Acceptance of Applications Checklist

Rosefield Solar Farm Section 55 Acceptance of Applications Checklist

Section 55(2) Acceptance of applications				
1	Within 28 days (starting day after receipt) The Planning Inspectorate must decide whether or not to accept the application for examination.	Date received	28-day due date	Date of decision
		26 September 2025	24 October 2025	23 October 2025
Section 55(3) – the Planning Inspectorate may only accept an application if it concludes that:		Planning Inspectorate comments		
Section 55(3)(a) and s55(3)(c): It is an application for an order granting development consent				
2	In accordance with sections(s) 14 to 30 of the Planning Act 2008 (the PA2008), is the development a Nationally Significant Infrastructure Project (NSIP) (or does it form part of an NSIP); and does the application state on the face of it that, in accordance with s31 of the PA2008, it is an application for a development consent order (DCO) under the	Yes The proposed development set out in schedule 1 of the Draft DCO (Doc 3.1) includes development falling within the categories in s14 of the PA2008. The development is for the construction of an onshore generating station in

DRAWING TITLE:
STREETS, RIGHTS OF WAY AND ACCESS PLANS
SHEET 8 OF 8

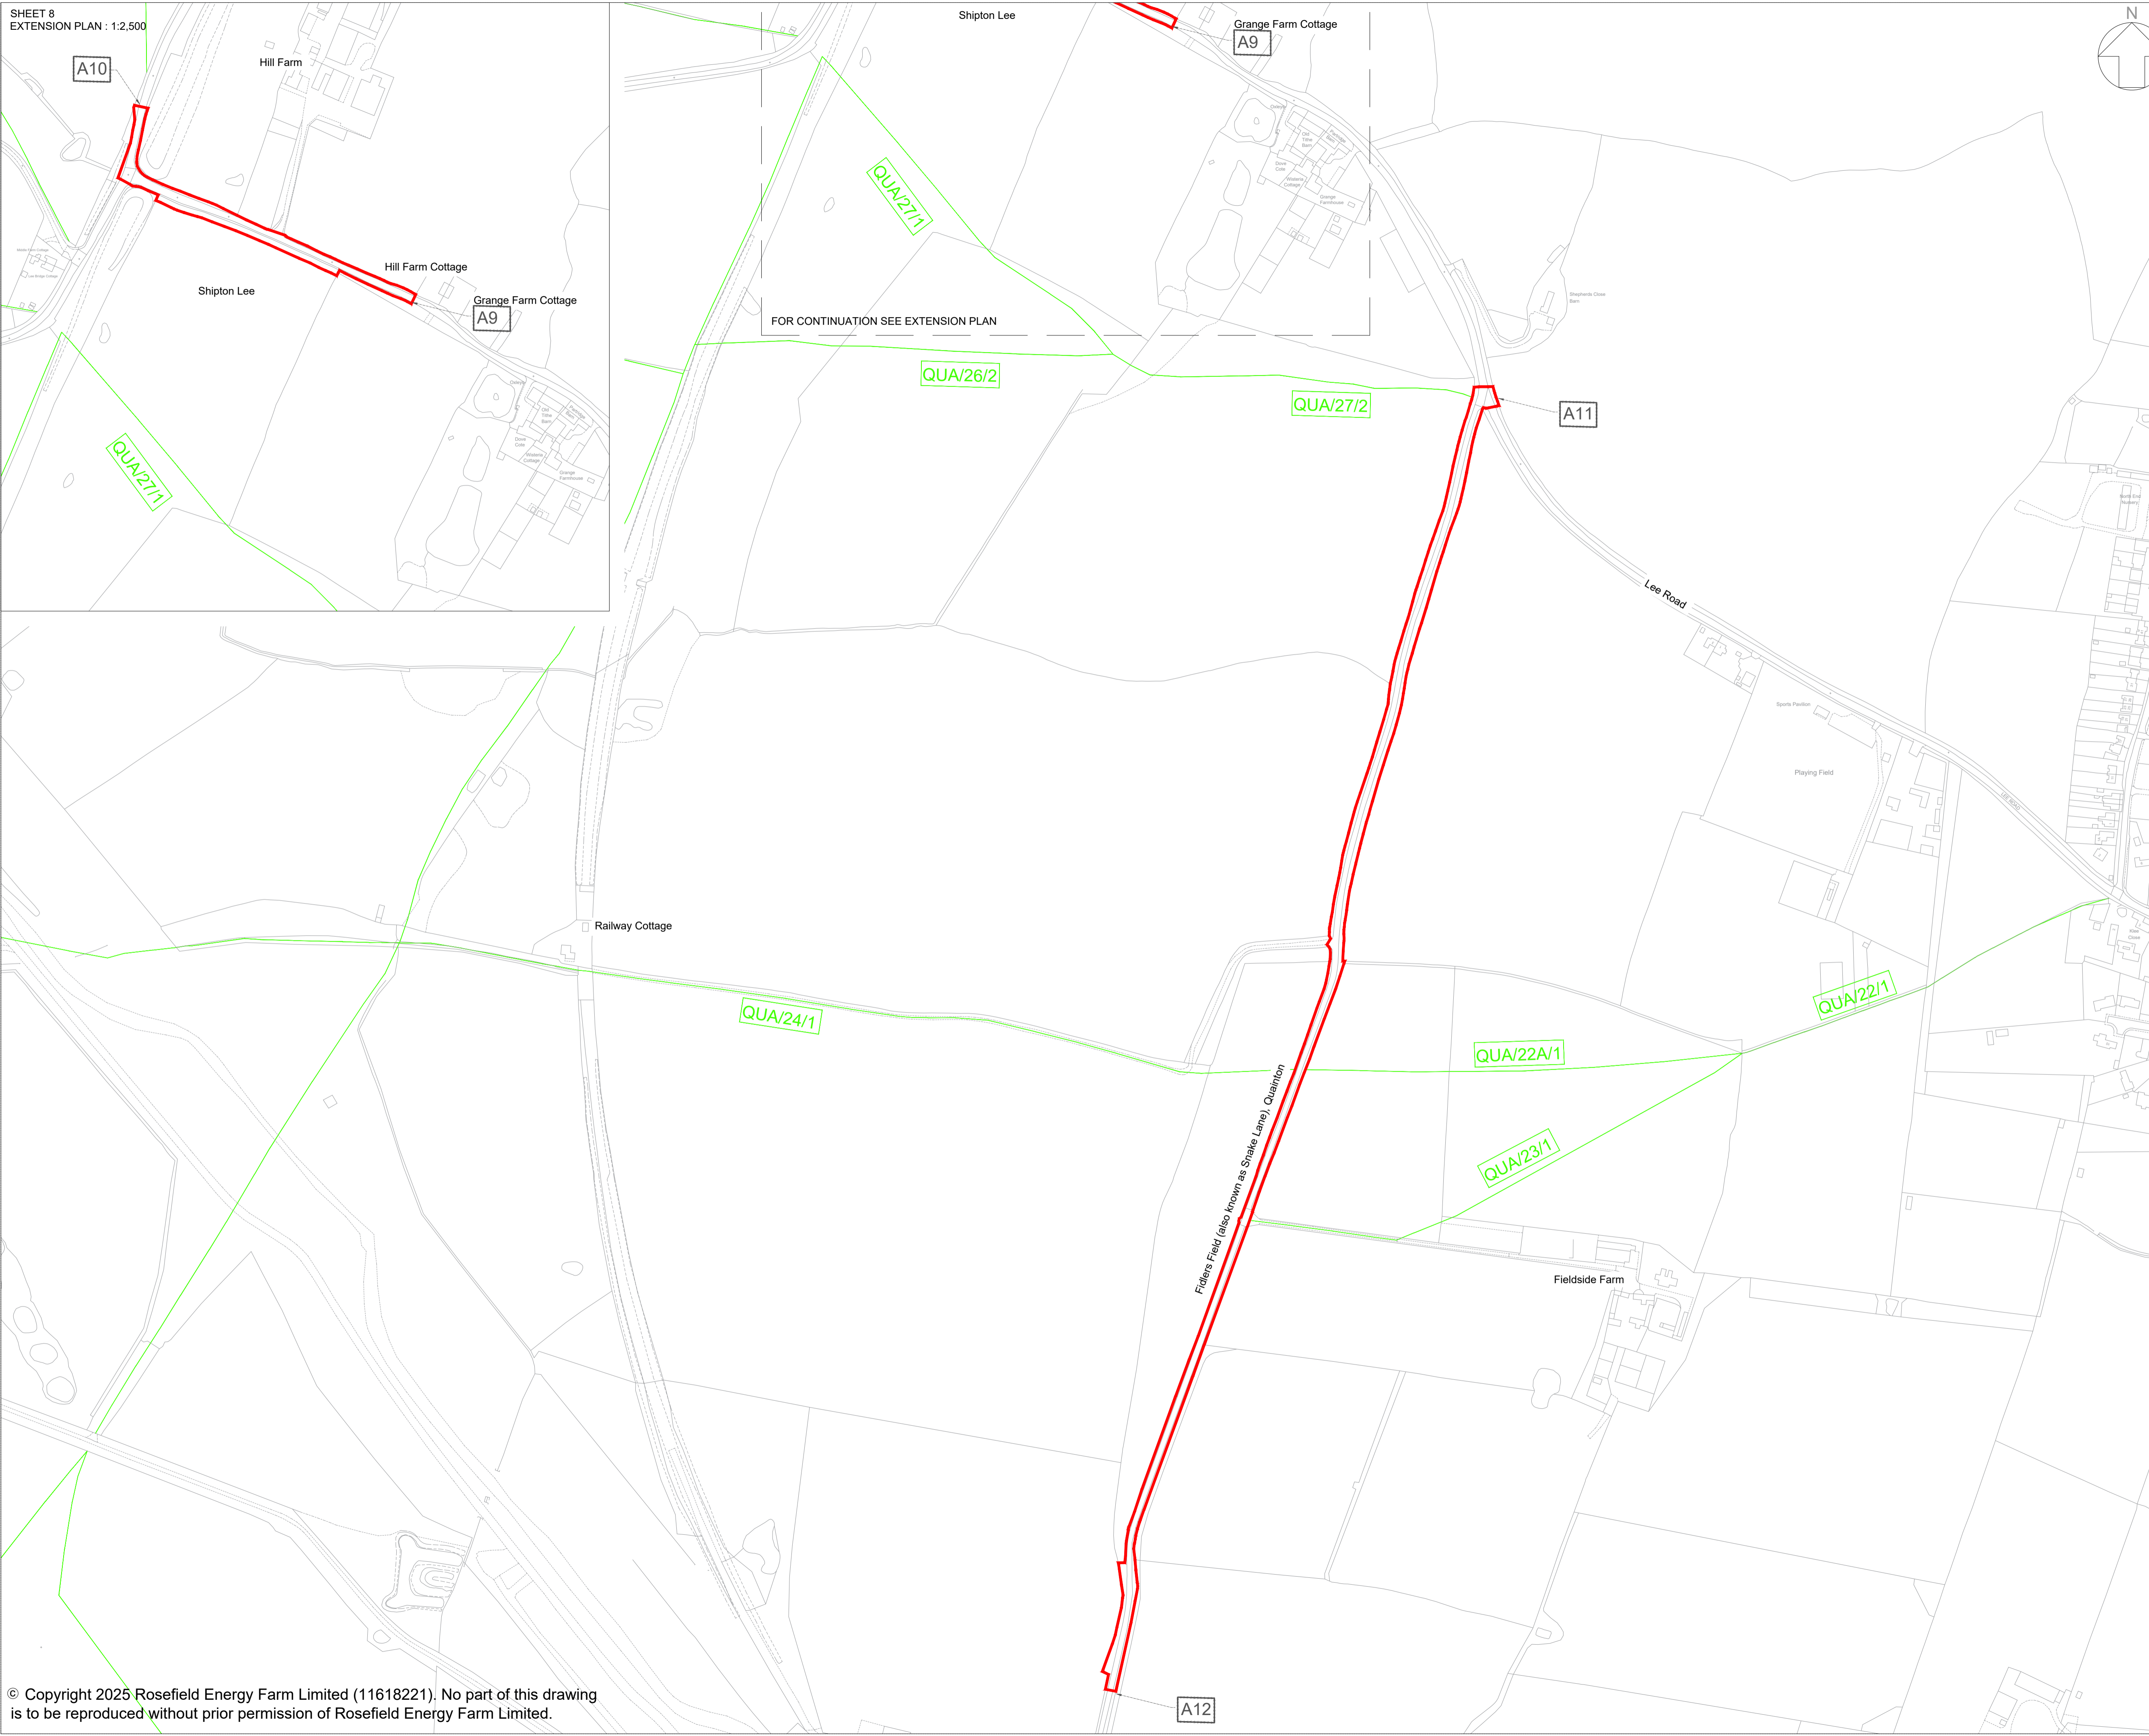
On sheet 8, 'Fidlers Field (also known as Snake Lane), Quainton' is not stated between A1 and A12 as mentioned in the draft Development Consent Order.

TITLE:
 FIGURE 3.1.2B
 HEIGHT PARAMETERS - PARCEL 1 & 1A

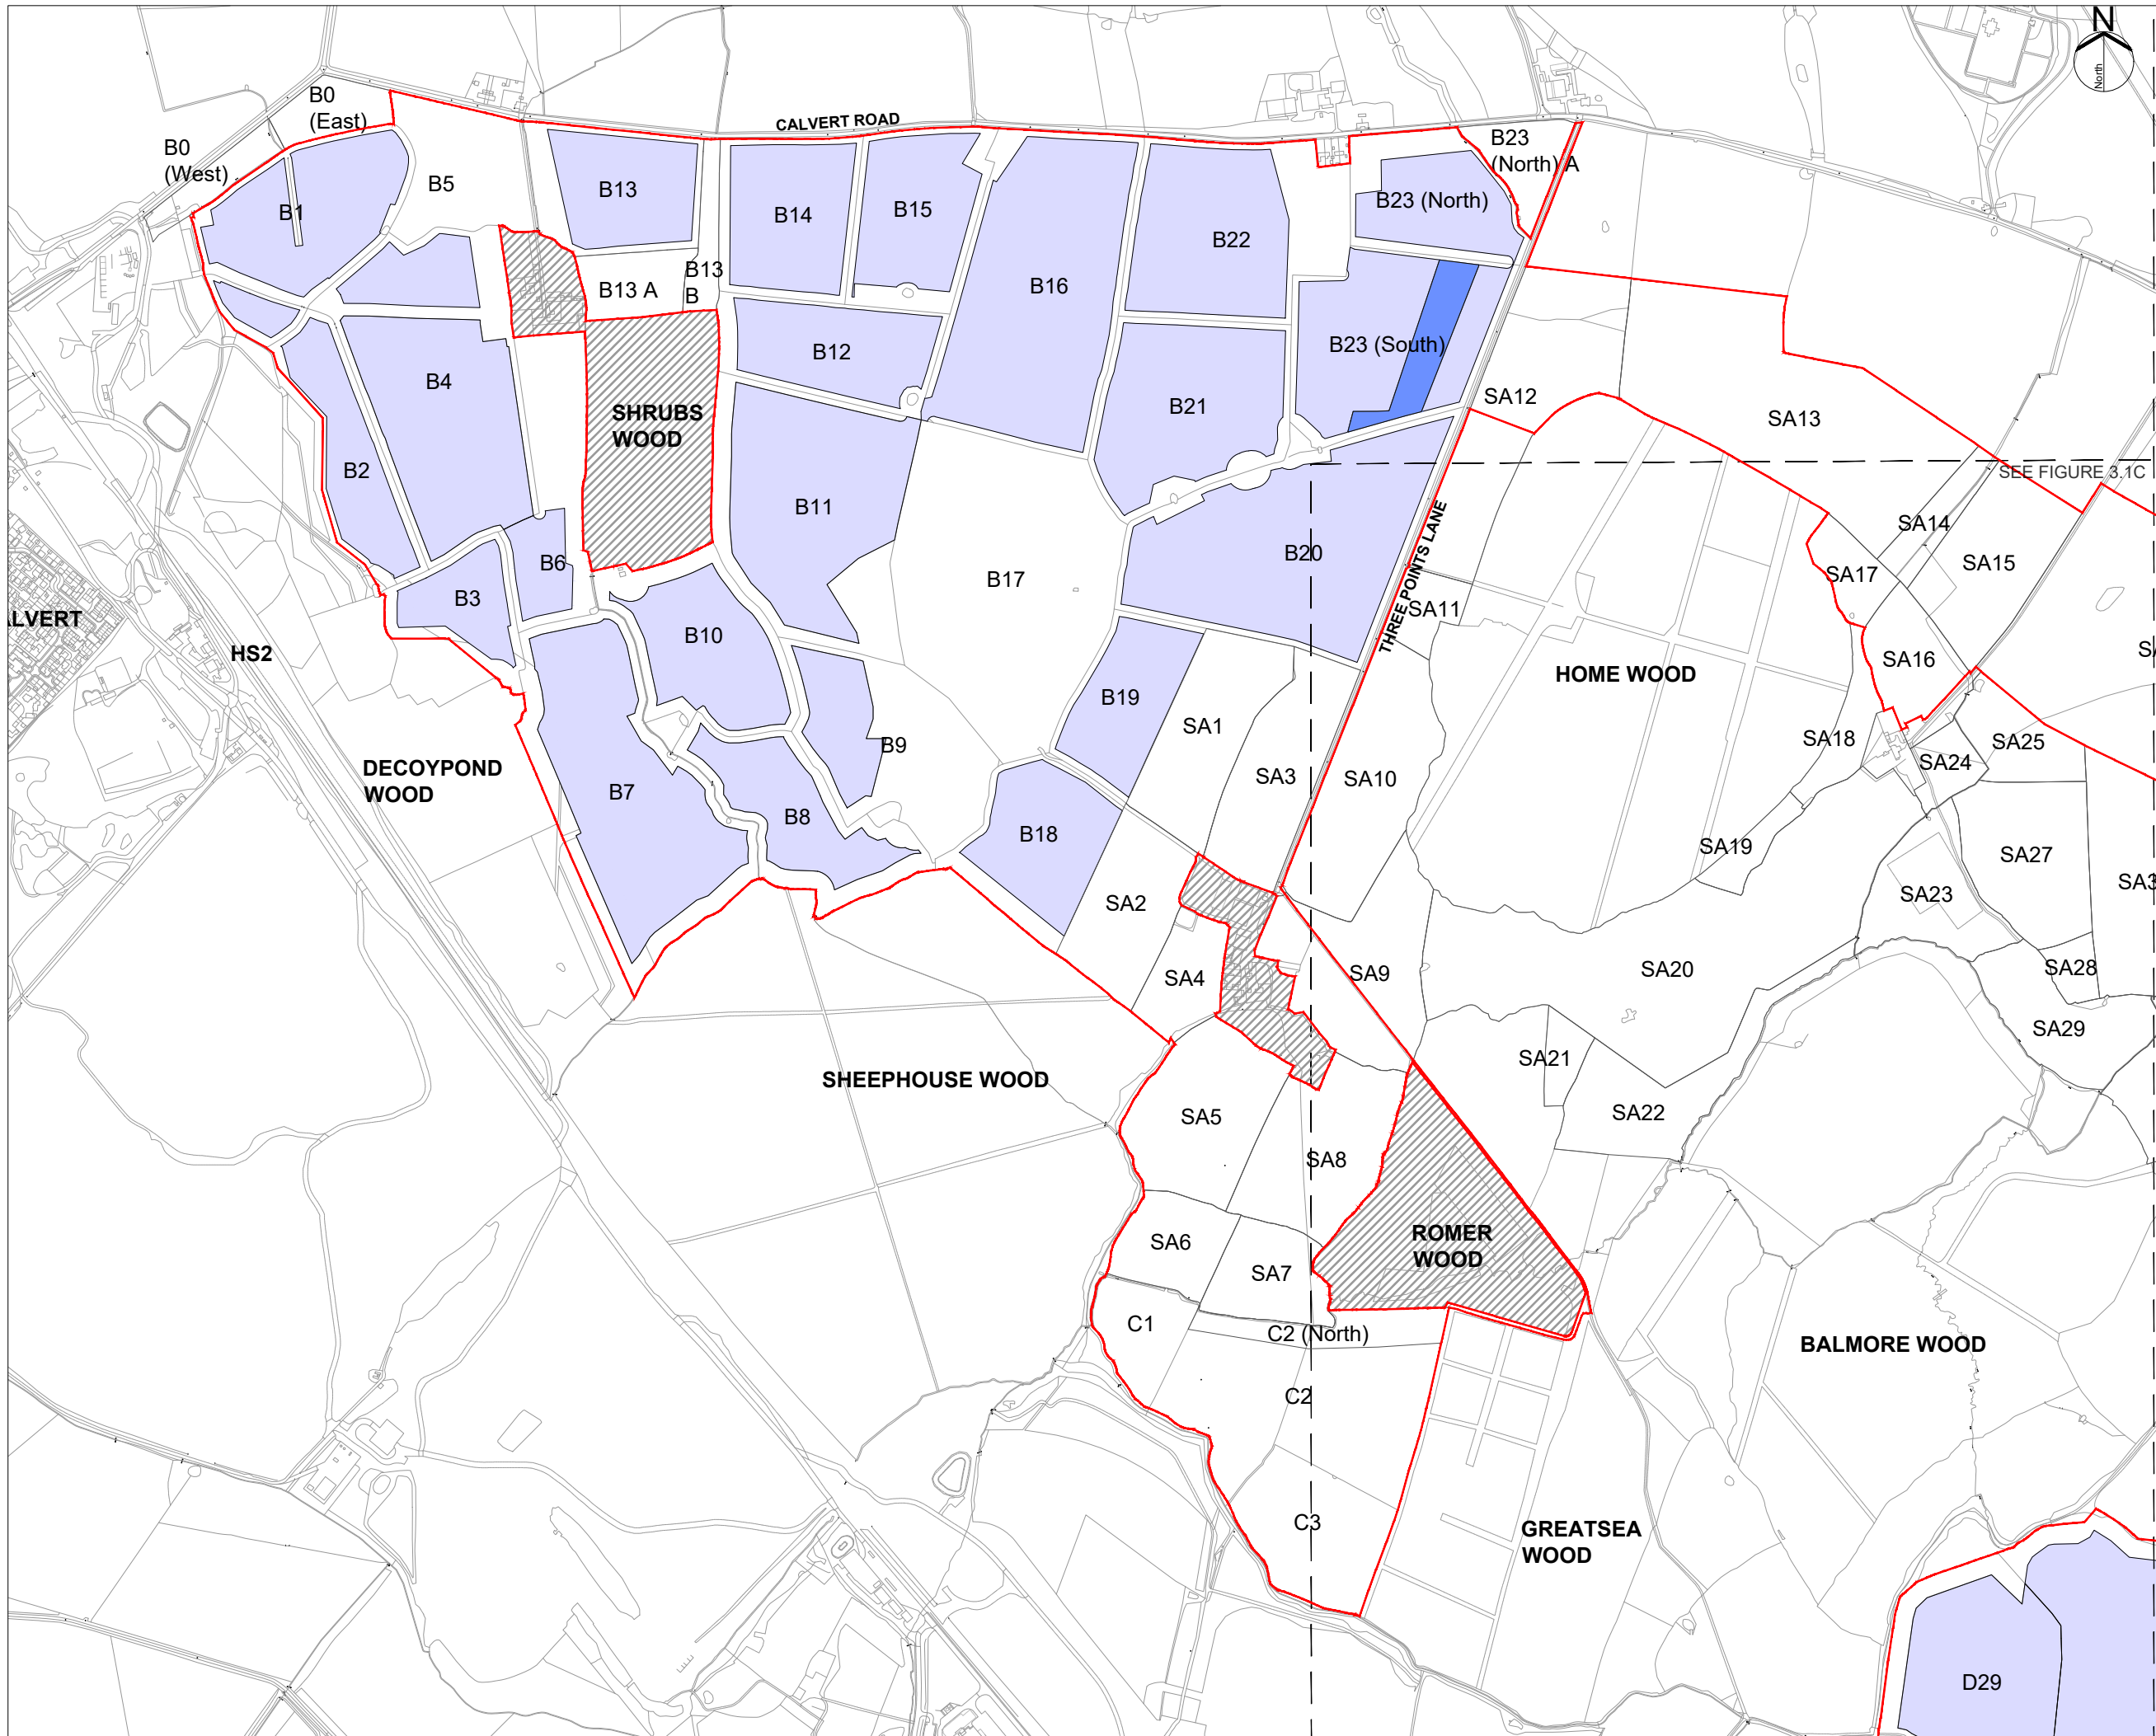
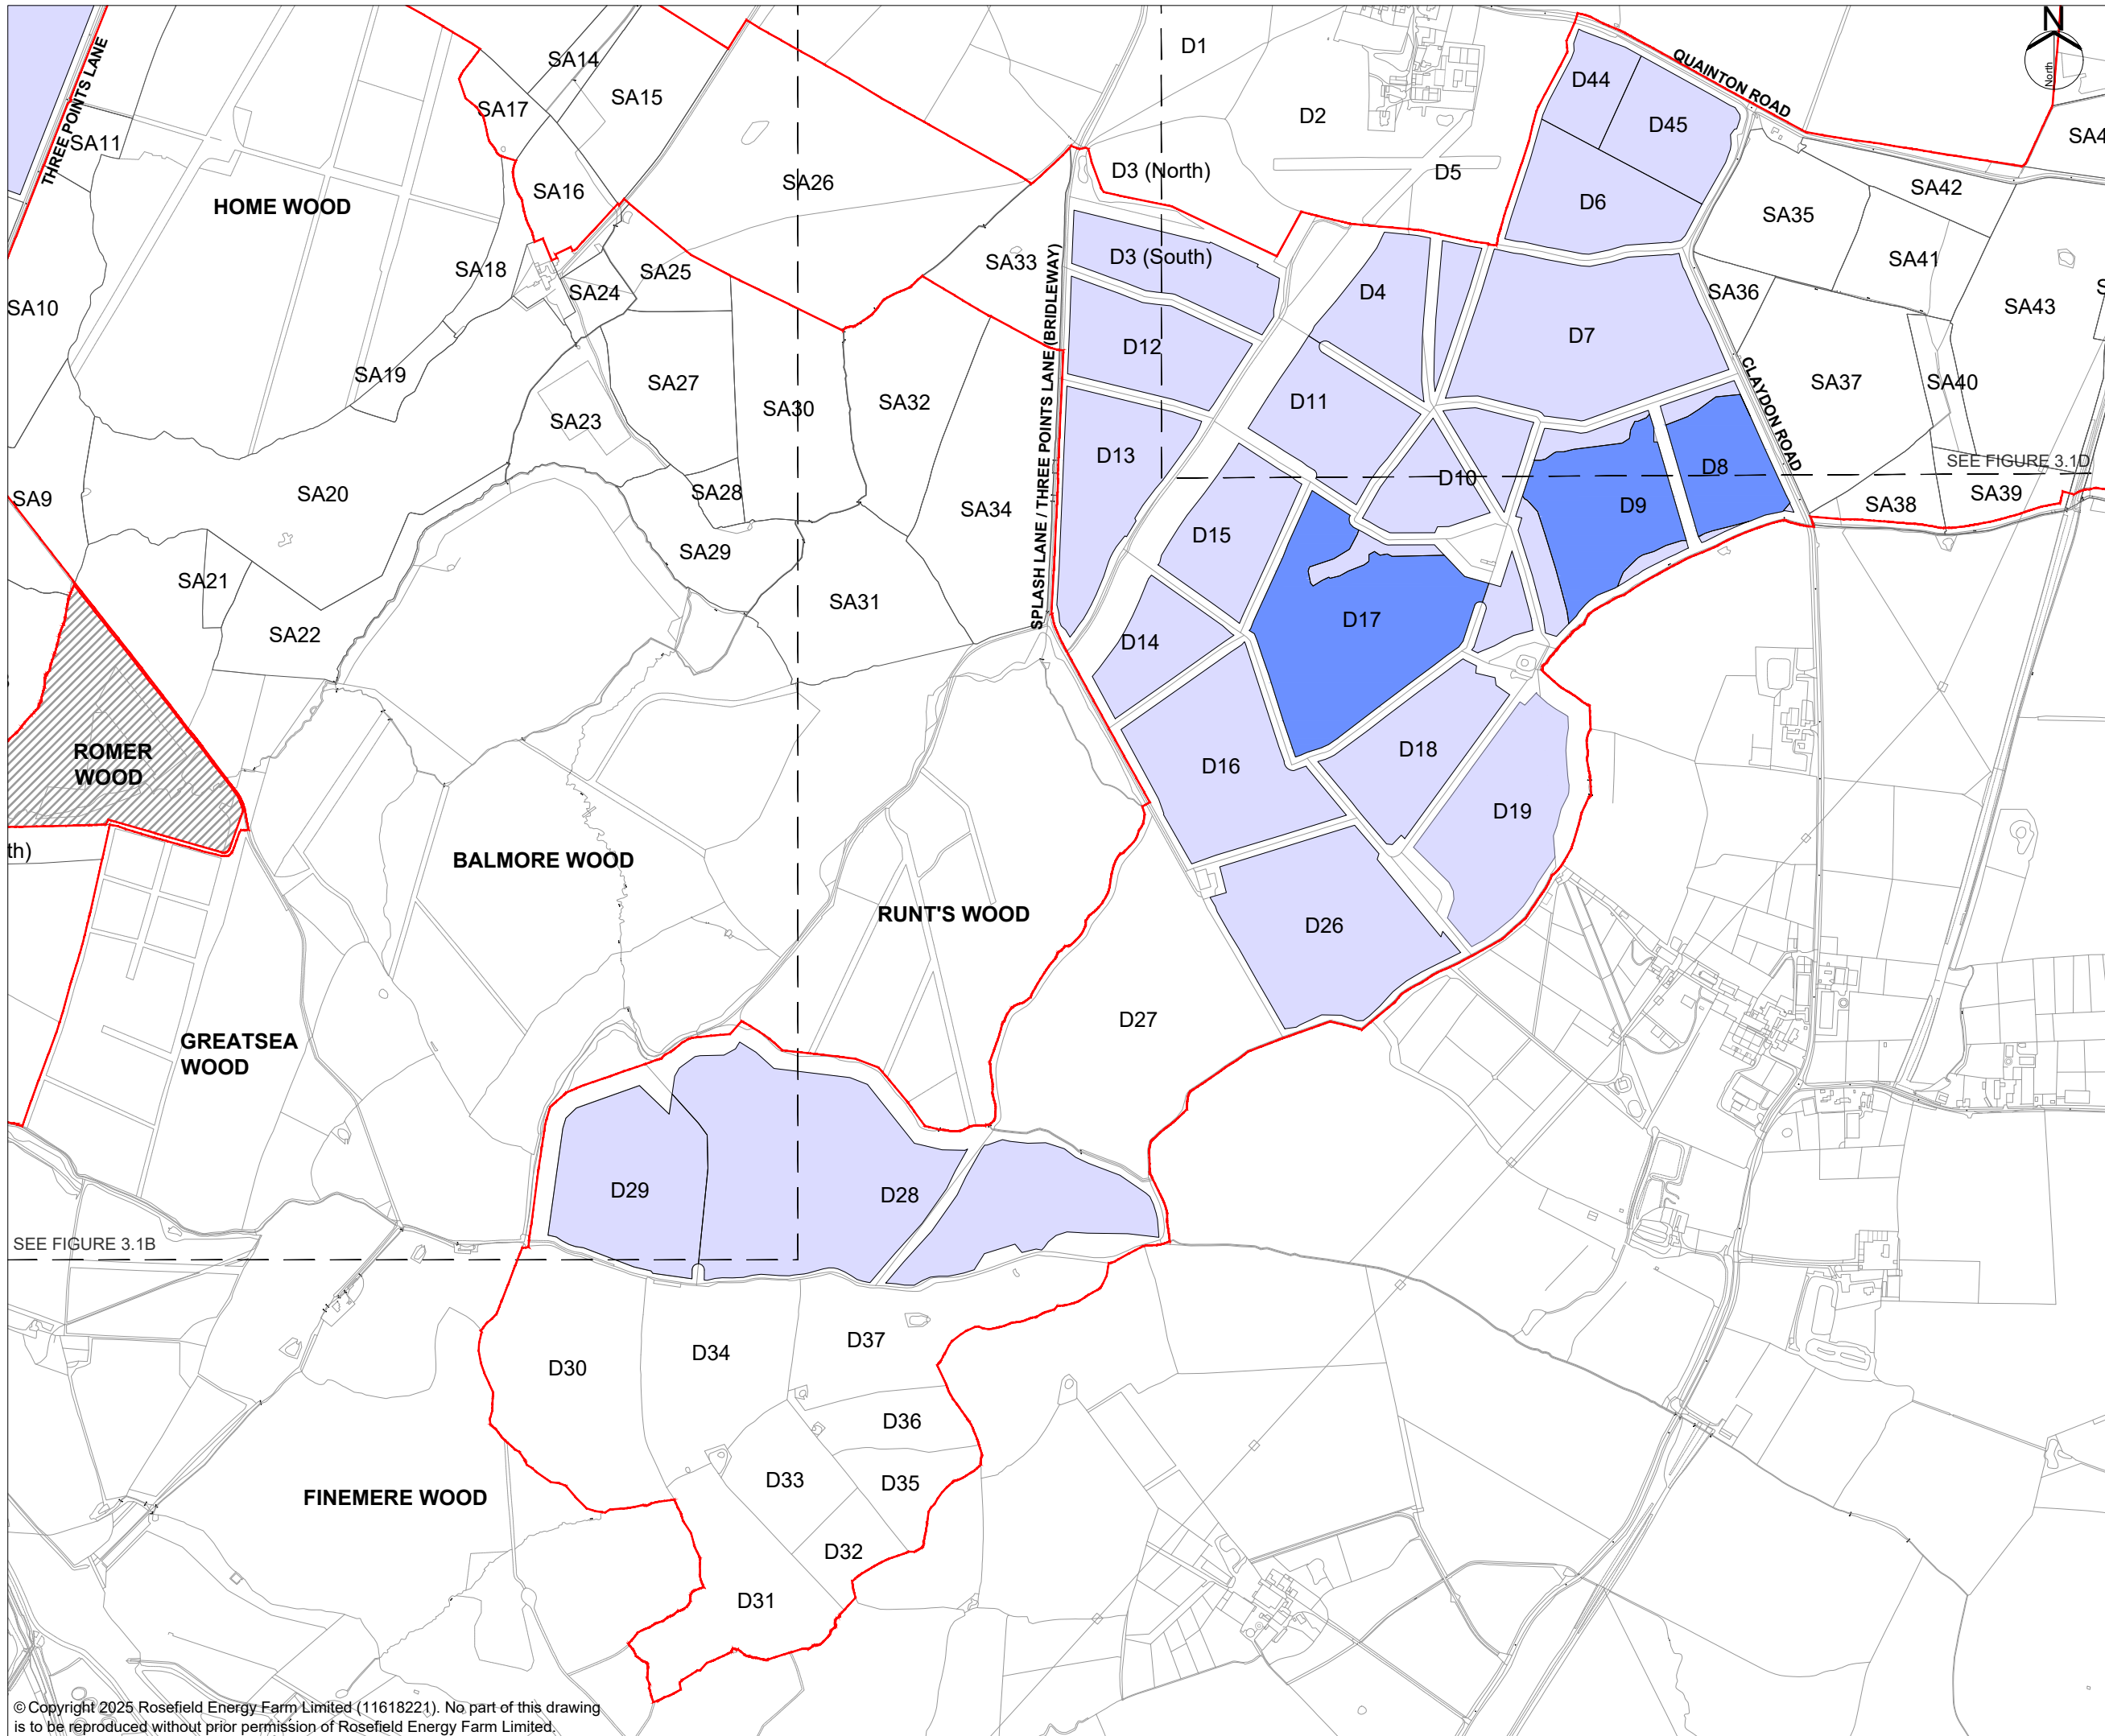
Revise shading to clearly distinguish between proposed development heights of up to 6m from those of up to 15m.
